Ribble Valley Borough Council
Housing & Development Control

Application no: **3/2019/0293**

Address: **Mill Farm Mill Lane Waddington BB7 3JJ**

Proposal: **Proposed demolition of existing garage/workshop, with a replacement holiday cottage to be constructed**

SHEET:
**PROPOSED PLANS &
ELEVATIONS**

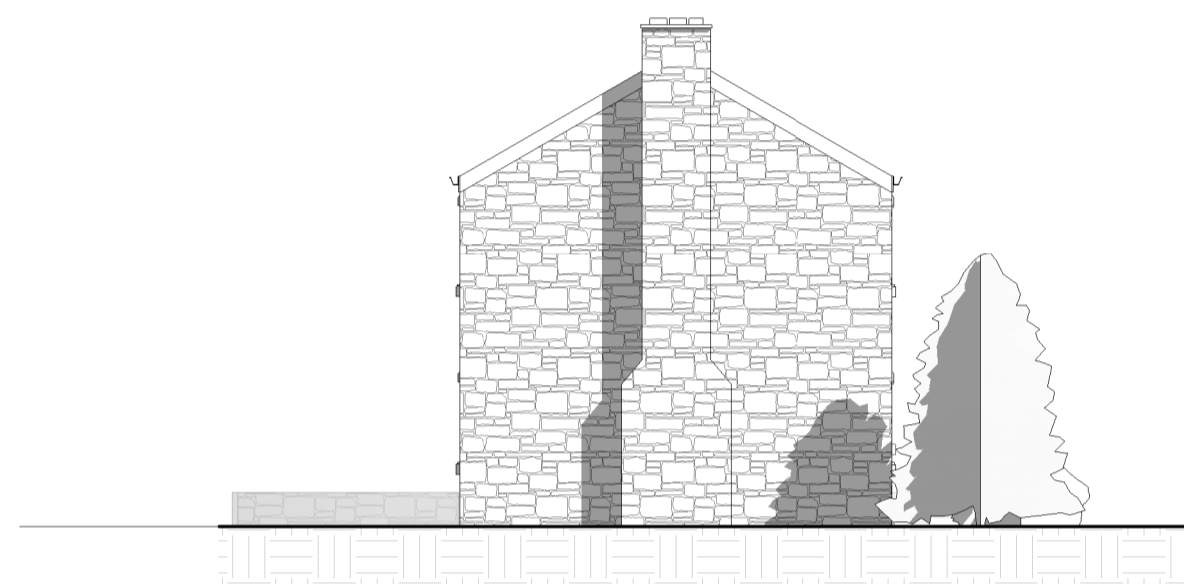
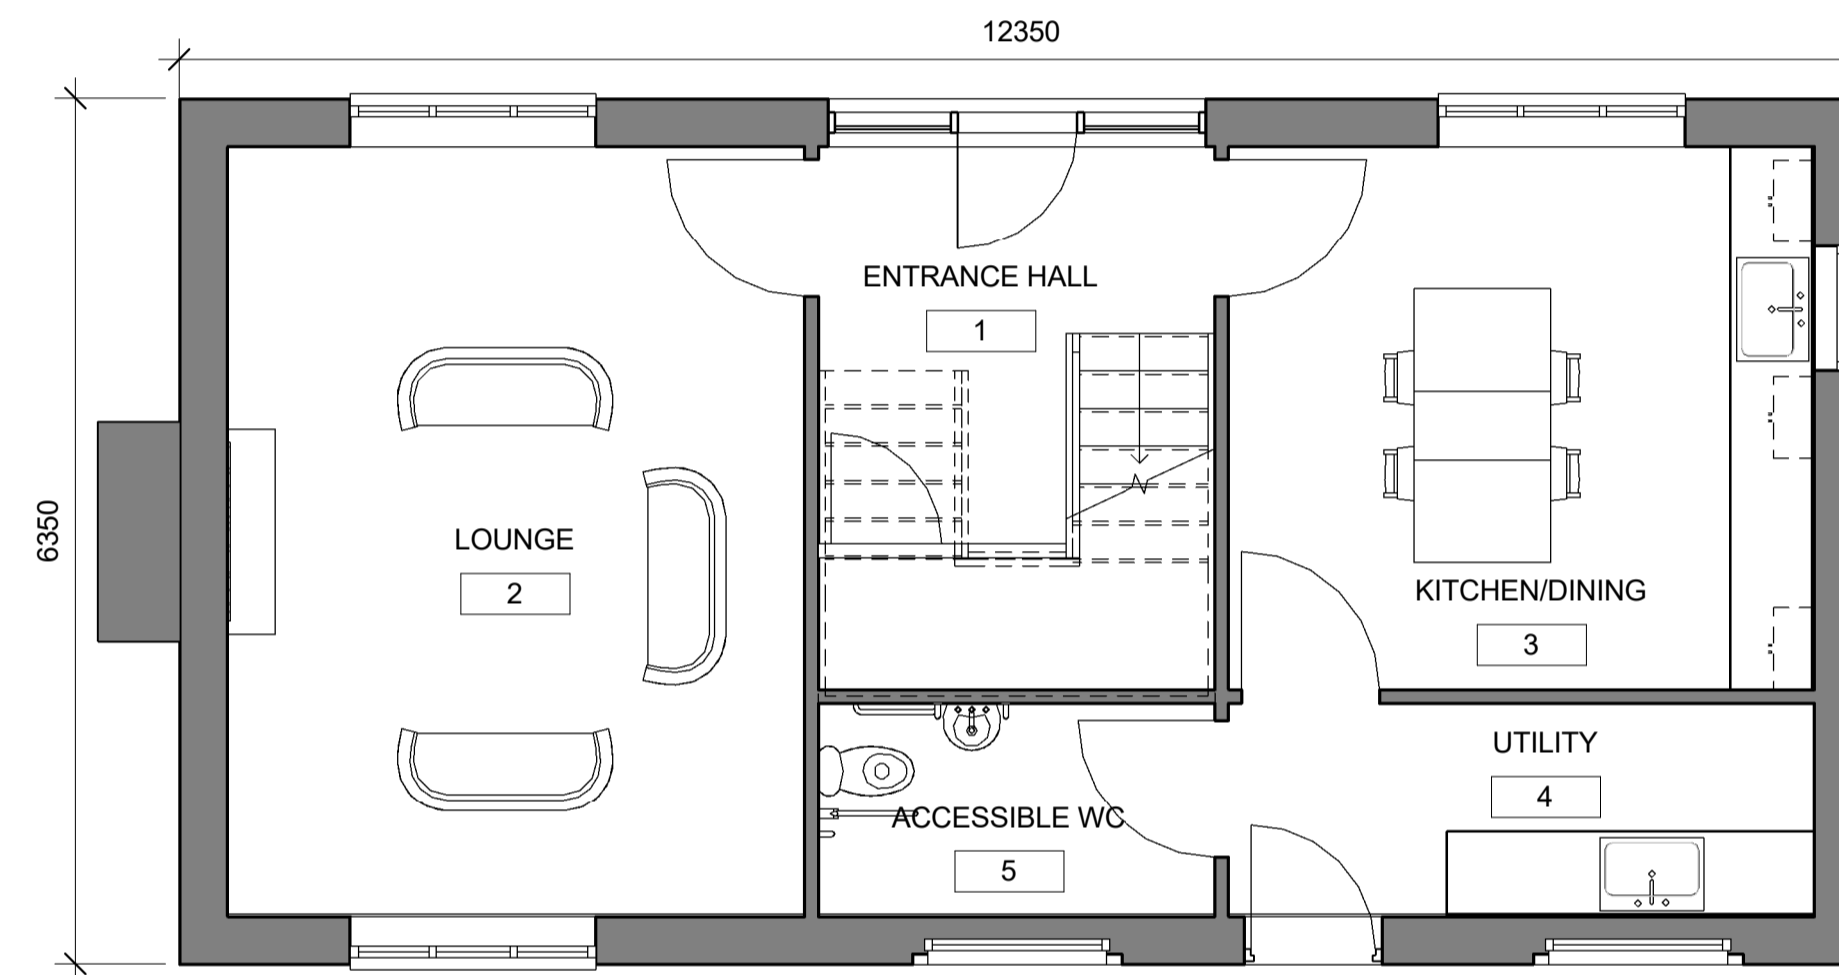
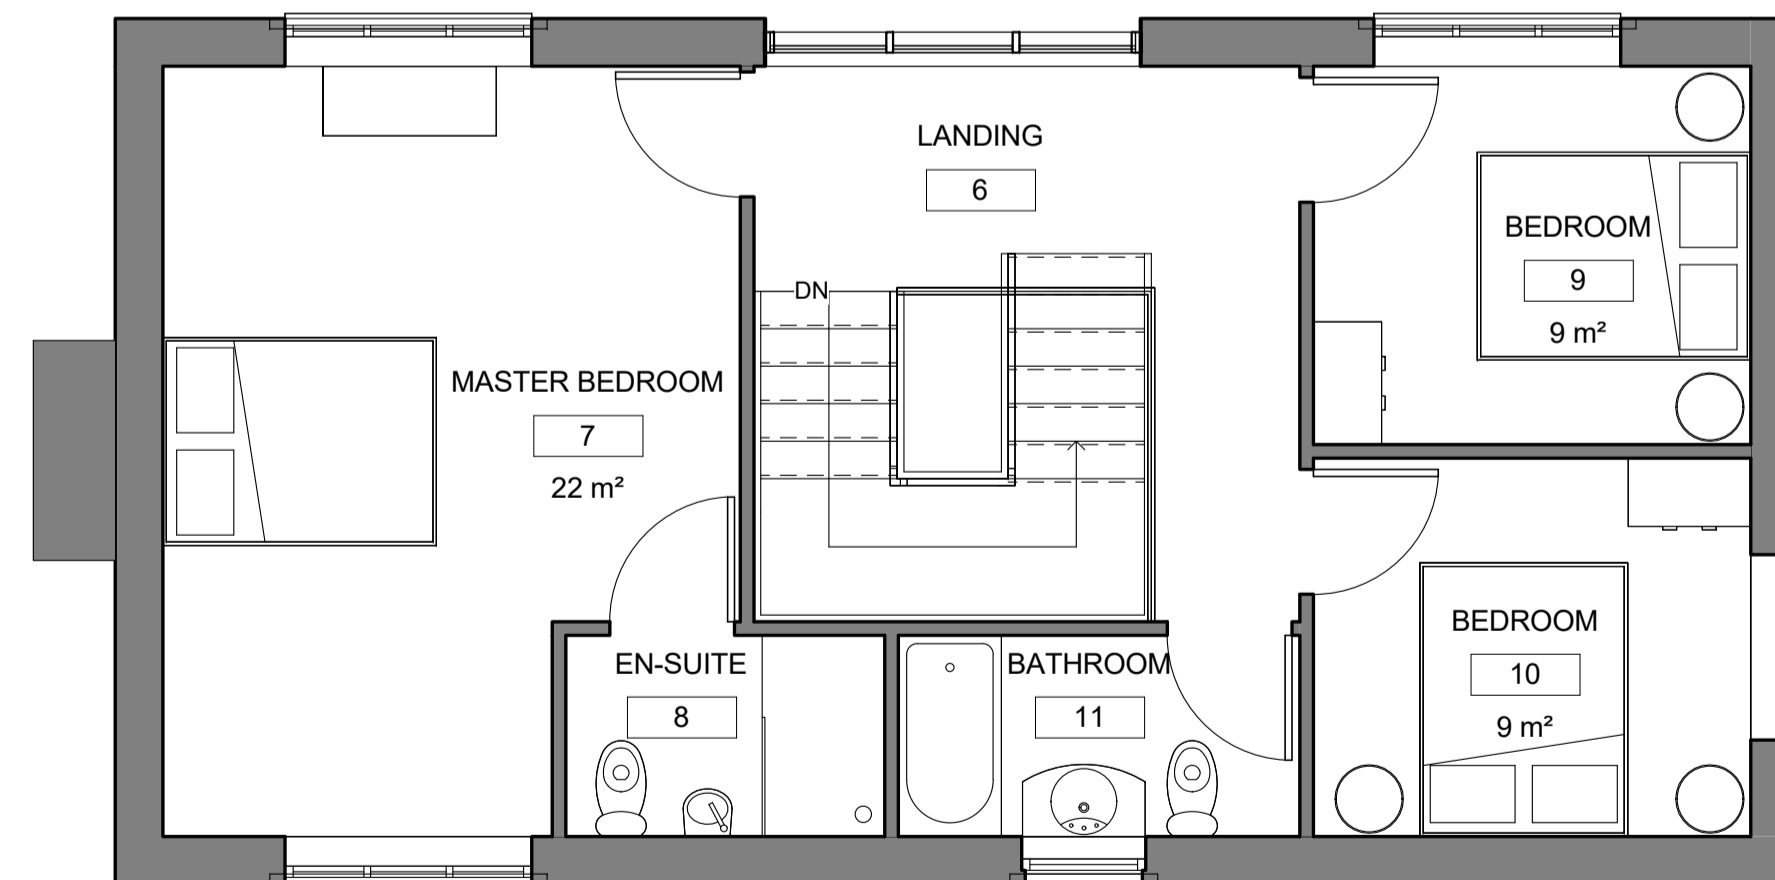
The proposed parking is to be sited within the curtilage of the holiday cottage where four parking spaces are proposed. However, in accordance with the planning statement "The new cottage would also provide over flow car parking for the existing 2 cottages" I would therefore consider four parking spaces to be sufficient.

In accordance with the proposed site plan, project number PHA/328 dated 22/03/2019;

I would raise no objection to the proposal on highway grounds.
